Phone: 0300 123 6780
Email: developeras@lancashire.gov.uk
Your ref: 3/2025/0612
Our ref: 3/2025/0612/HDC/KW
Date: 18 December 2025

Location: The Palace Market Place Longridge PR3 3RR
Proposal: Proposed change of use from vacant cinema (sui generis) to children's role play centre (use class E(d)) with ancillary cafe (use class E (b)). External alterations to the building to include alterations to fenestration and insertion of new first floor window.
Grid Ref: 360592 437207

PROPOSED CYCLE STORE PLAN
Scale 1:50

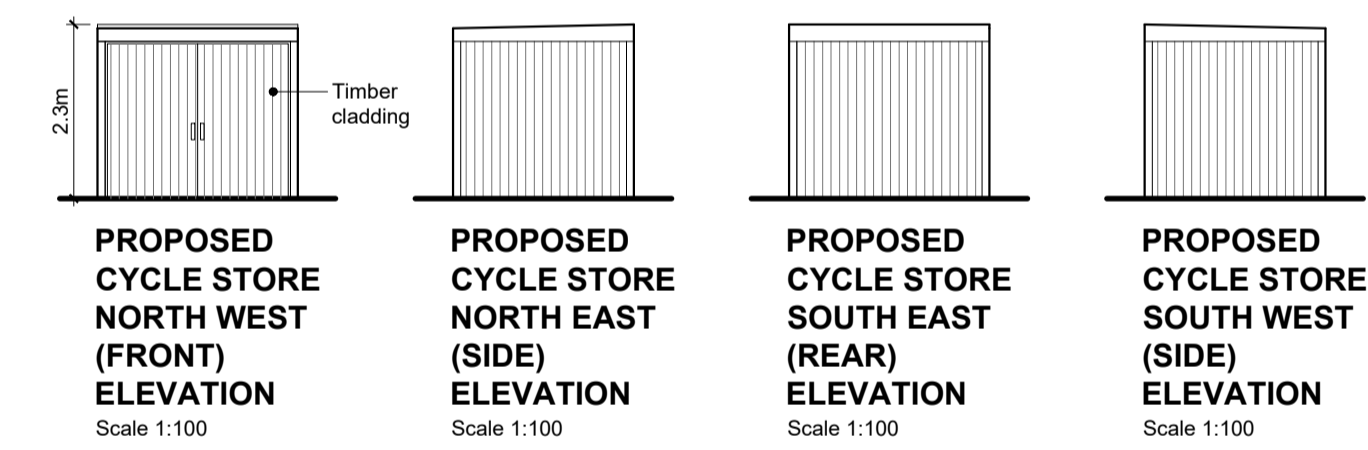
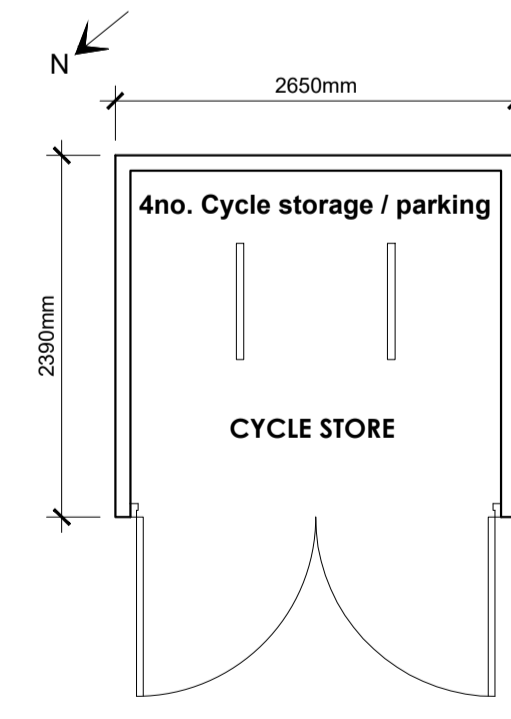
The site would also benefit from the introduction of covered secure cycle storage within the development to ensure the provision and availability of adequate cycle parking and the promotion of sustainable forms of transport, which can be utilised by employees.

2. Prior to first occupation cycle storage provisions for the residential unit shall be submitted to the Local Planning Authority, in consultation with the Local Highway Authority. These cycle facilities shall thereafter be kept free of obstruction and available for the parking of bicycles only at all times.
